State Significant Development Application SSD-21208499
Glanmire Solar Farm
Site: 4823 Great Western Highway, Glanmire (Lot 141 in DP 1144786)

I make the following submission in objection to the State Significant Development Application SSD-21208499 (**Application**), by which Elgin Energy Pty Ltd (**Elgin Energy**) seeks consent to develop a 60 MW solar farm with a 60 MW / 60 MWh battery energy storage system and associated infrastructure (**Development**).

Objection to the Environmental Impact Statement

Glanmire Solar Farm
Indicative Site Layout Plan

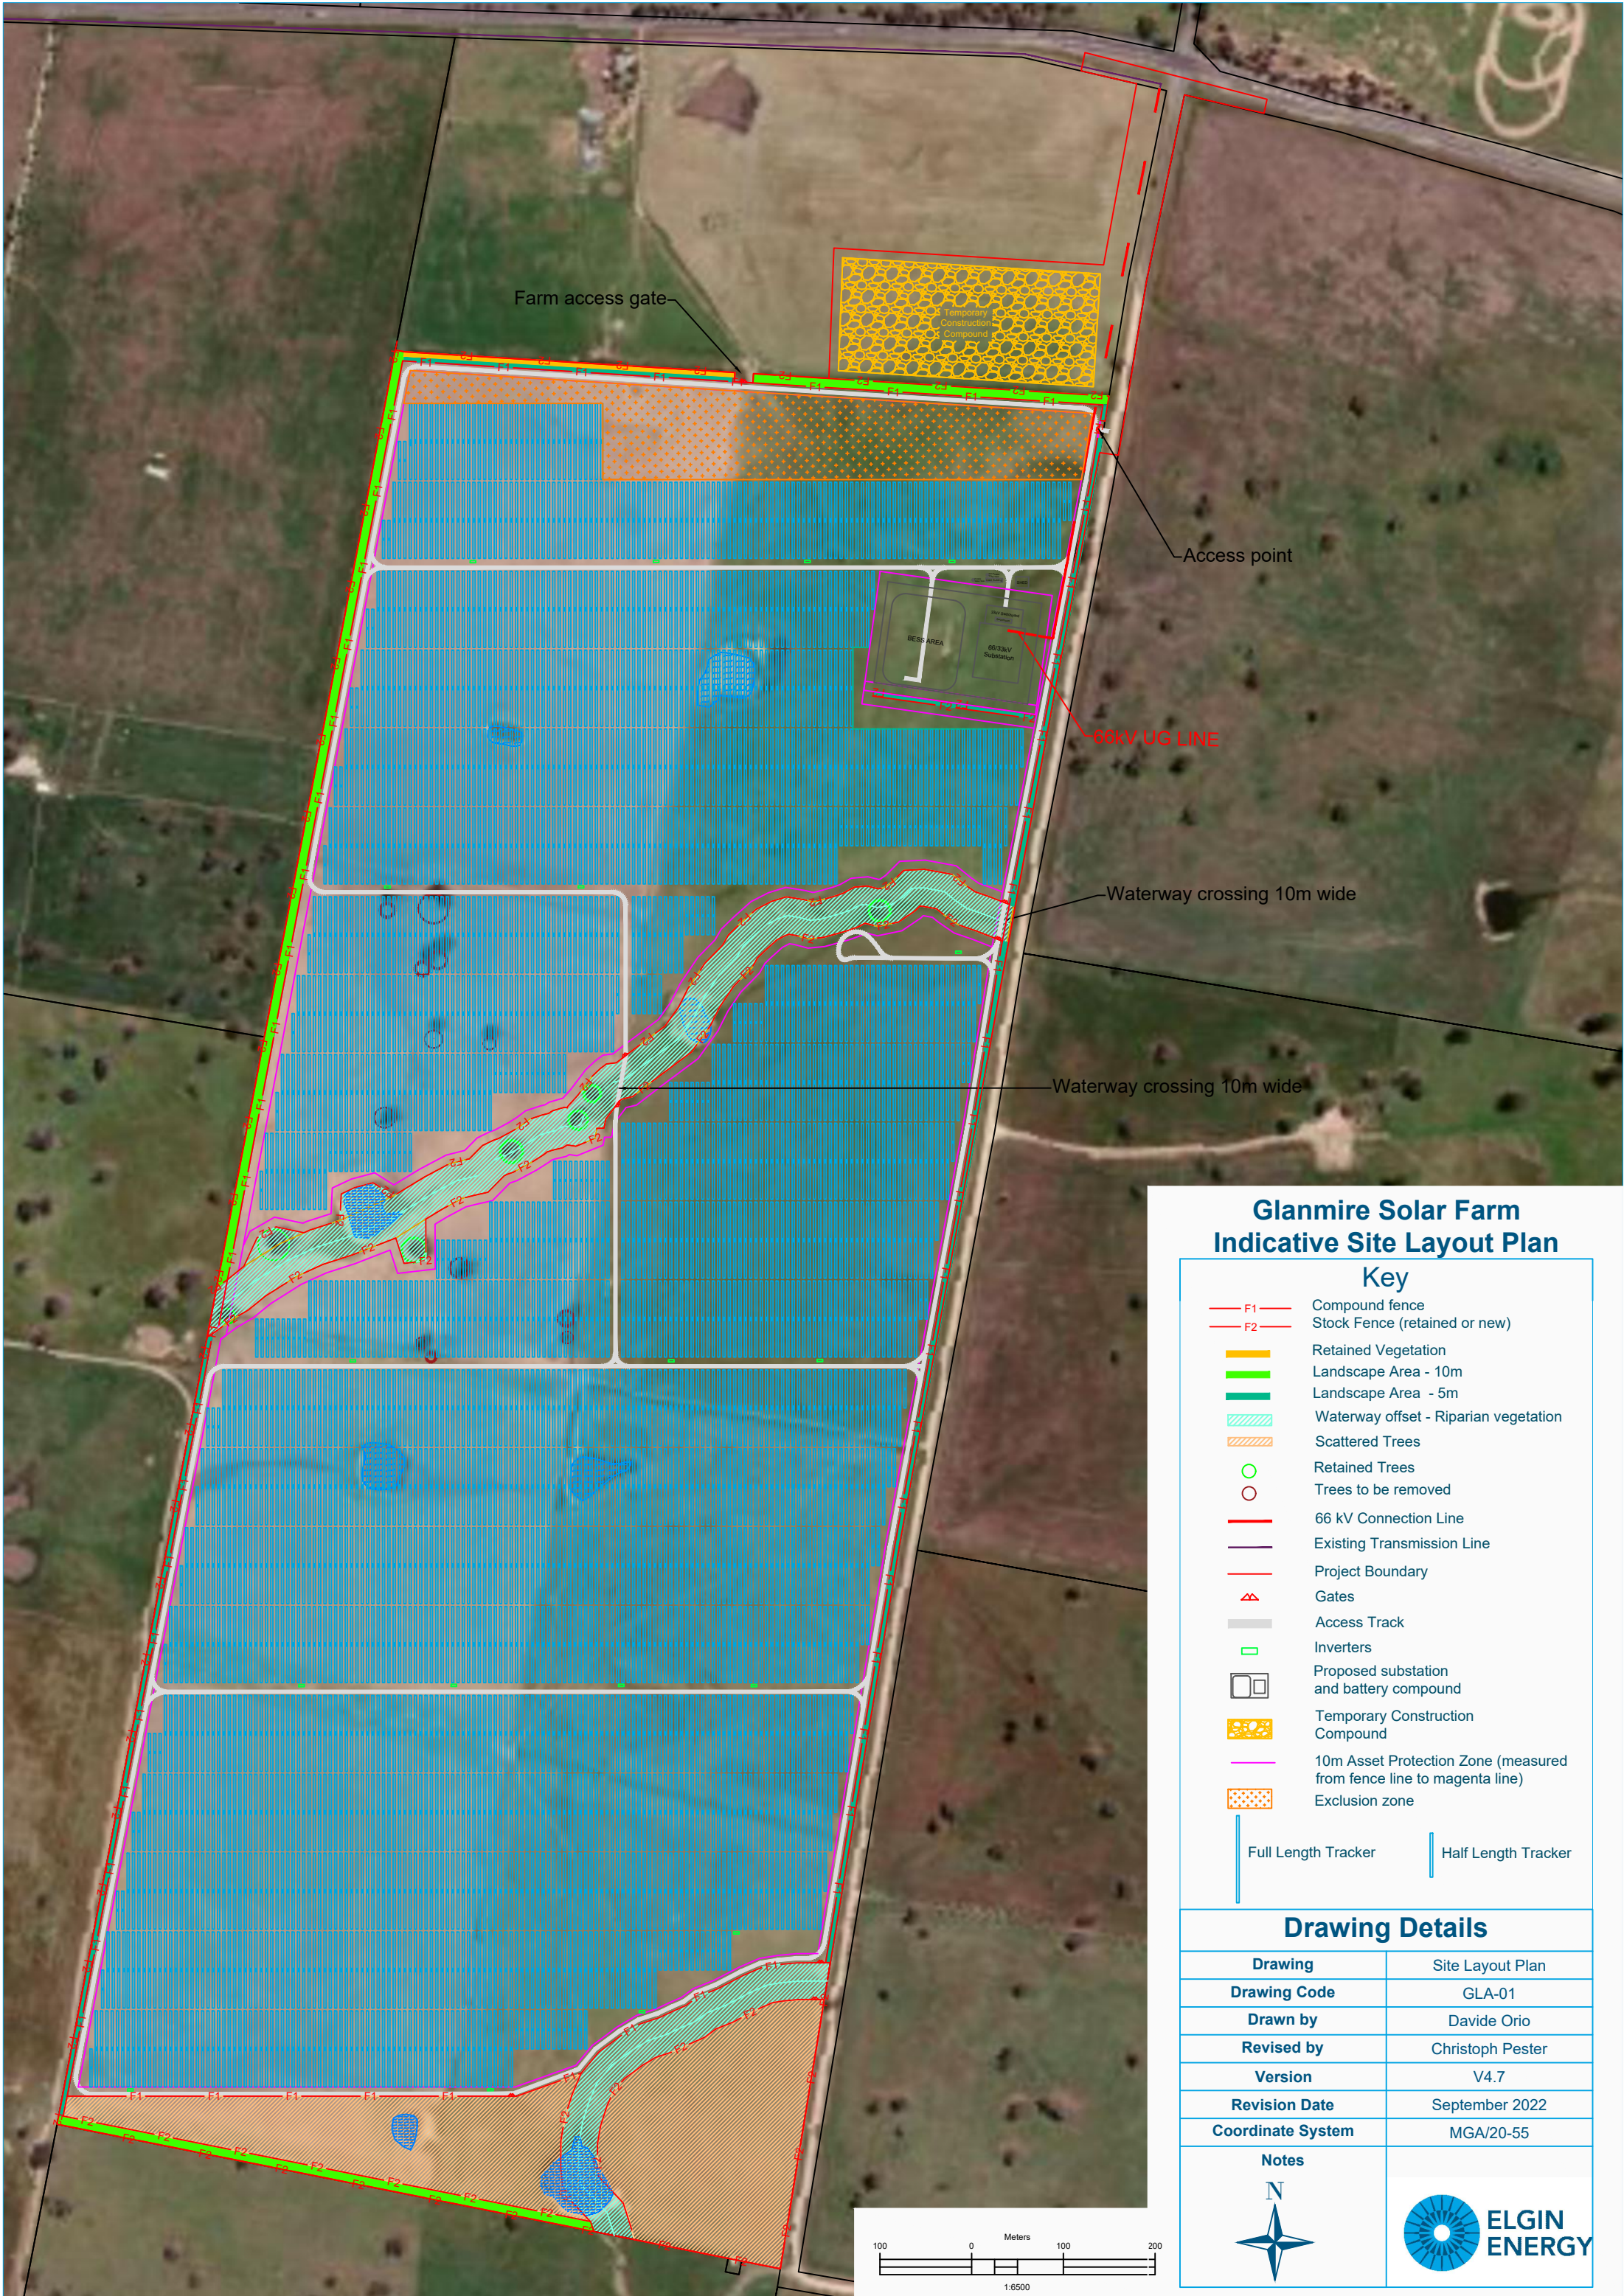
I wish to object to the setbacks for the Asset Protection Zone as proposed by the Application.

The proposed 10m setback around the solar farm buildings are inadequate and will not provide a sufficient buffer for fire events emanating on the Site or sweeping across the Site.

To mitigate against the risks of fire, as a minimum, a 30m setback is required to ensure that all mitigation occurs on the Site, and the development or use of my Land is not prejudiced by the solar farm.

My Land will be used for cropping activities.

Where a solar energy project is located adjacent to a horticultural or cropping activity, the solar array should be setback from the property boundary by at least 30m to mitigate any heat island effect.
